**RE: EXHIBITION OF STATE SIGNIFICANT DEVELOPMENT (SSD 8926) FOR 2 PERCY STREET, AUBURN**

Thank you for providing the opportunity to comment on the exhibition of the proposed State Significant Development - SSD 8926 (new K-12 school) at 2 Percy Street, Auburn.

**SSD Issues**

01 PLAN
Level 1 (Ground)
Scale 1:500

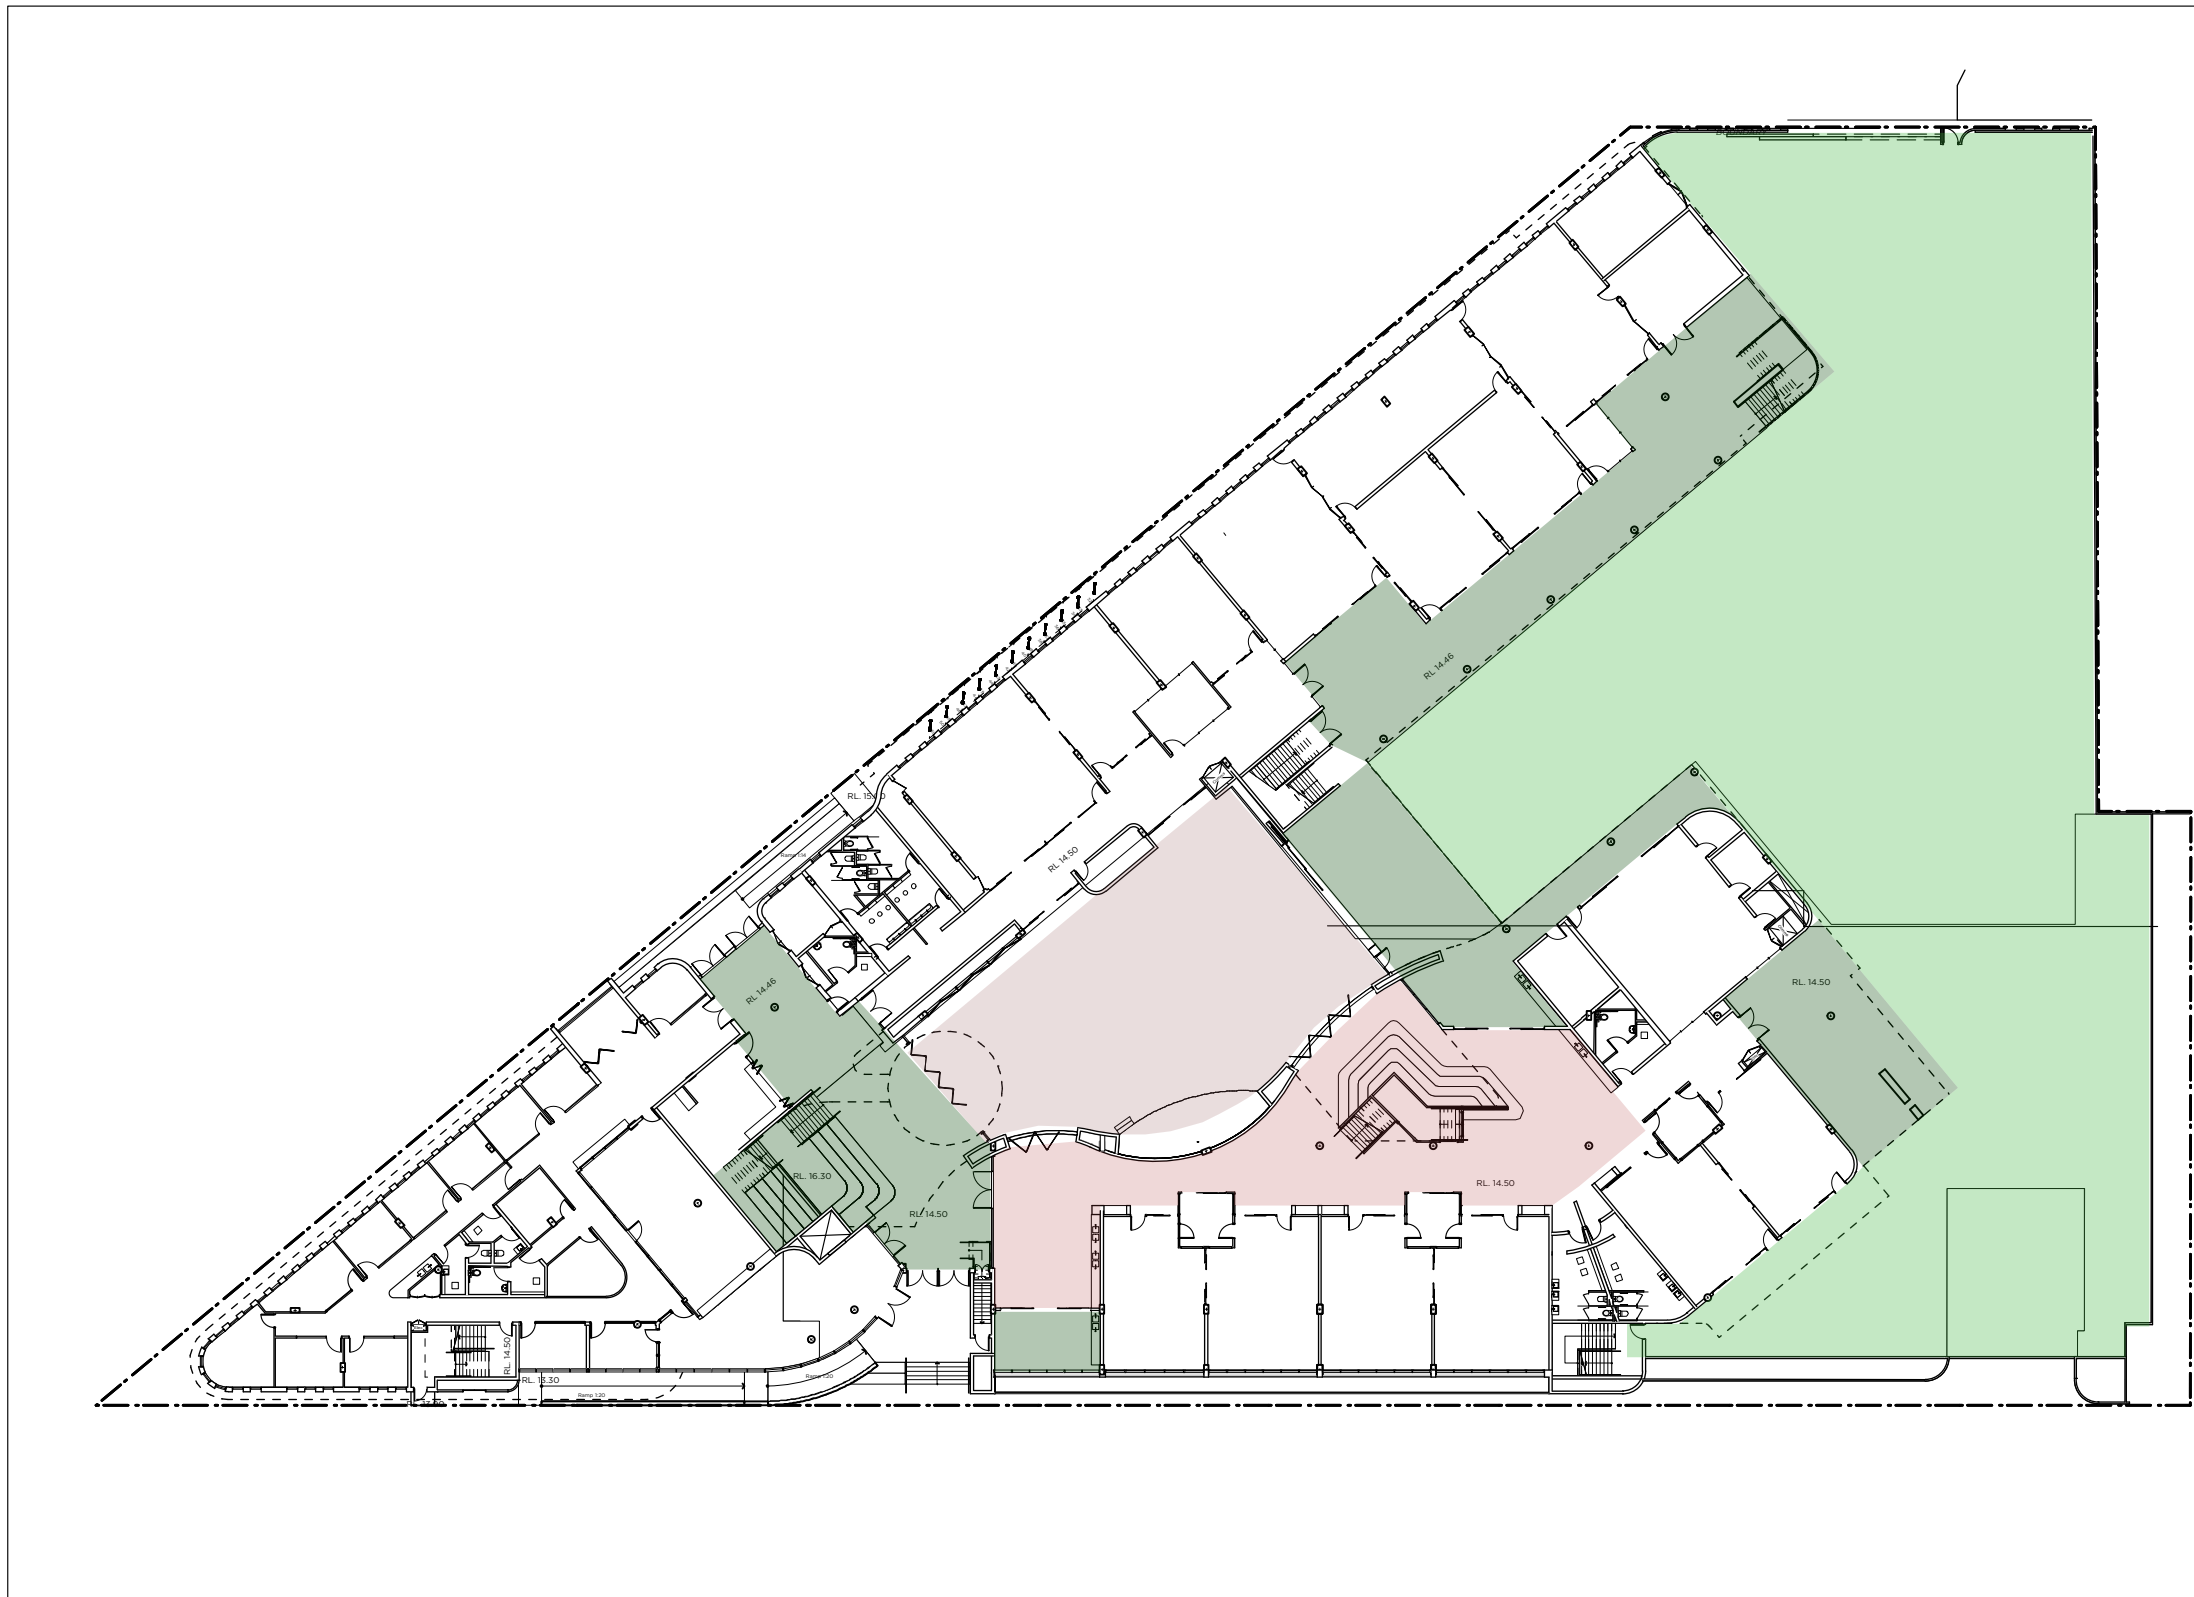
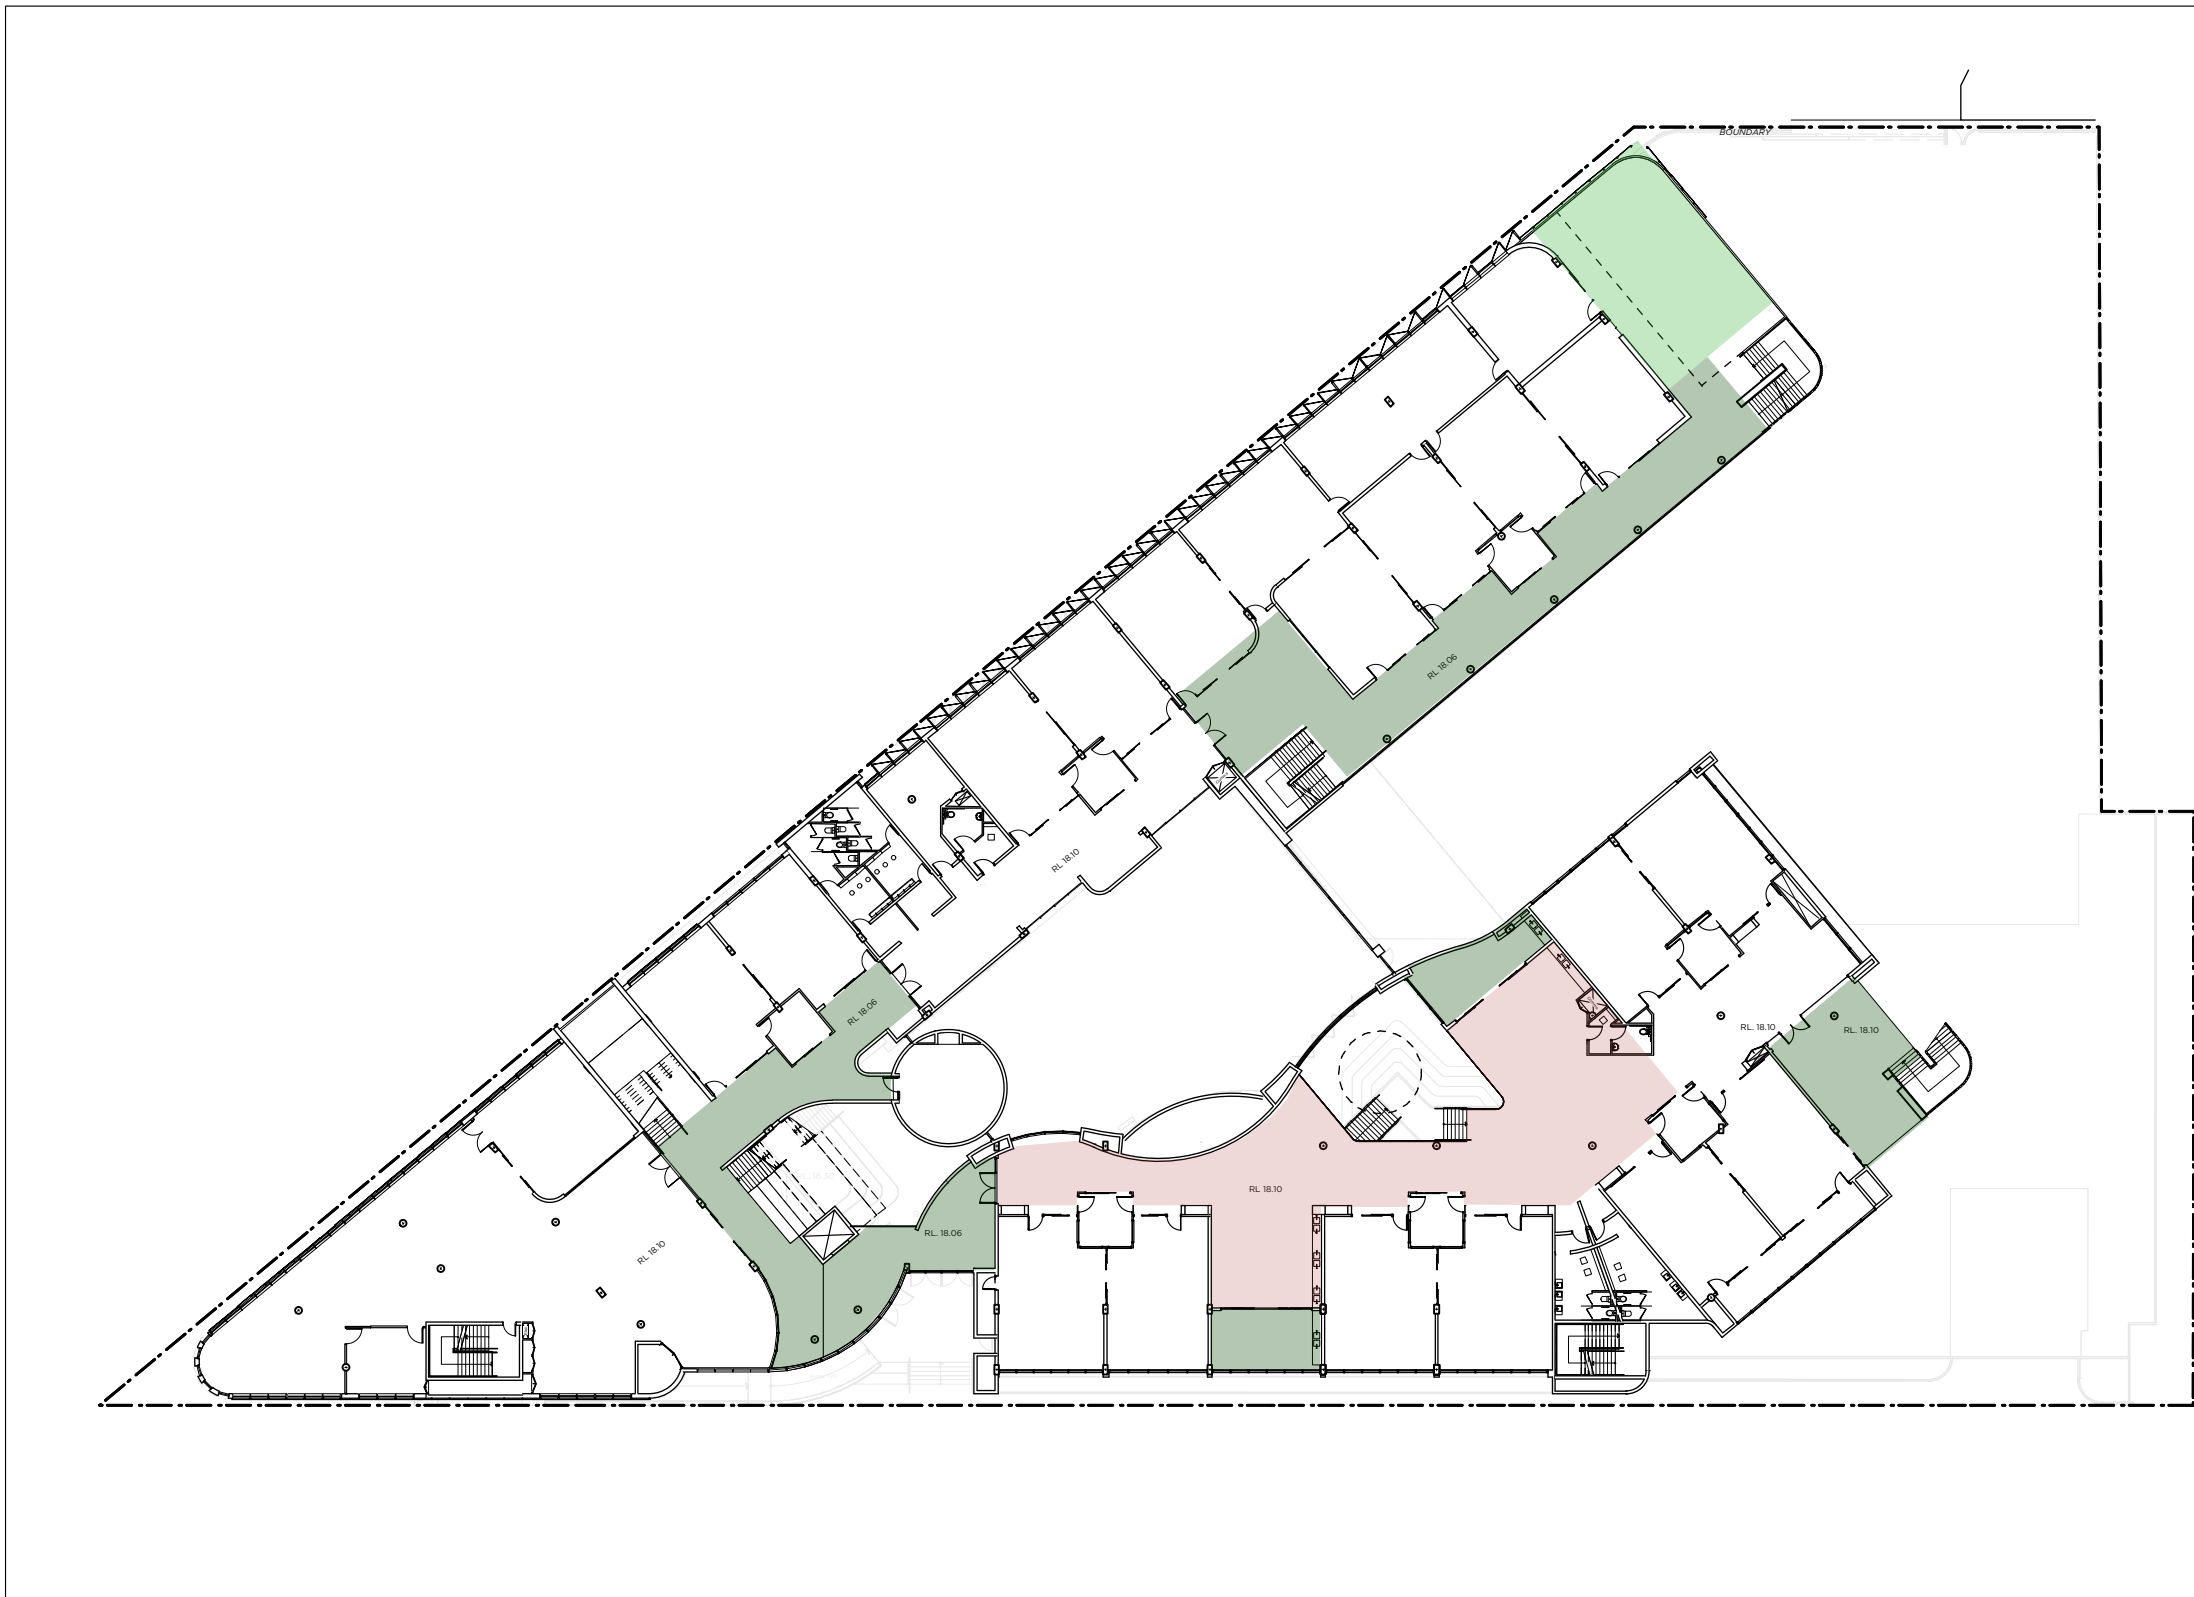
#### **7. Play/open space calculations (Ref drawing DA611)**

This drawing does not indicate a percentage or quantify how much active/passive play and open space is proposed for each level of the proposed development. Further, the plans show 'under cover space' and it is not clear if this type of space can be taken as play and/or open space. Clarification of this is recommended.
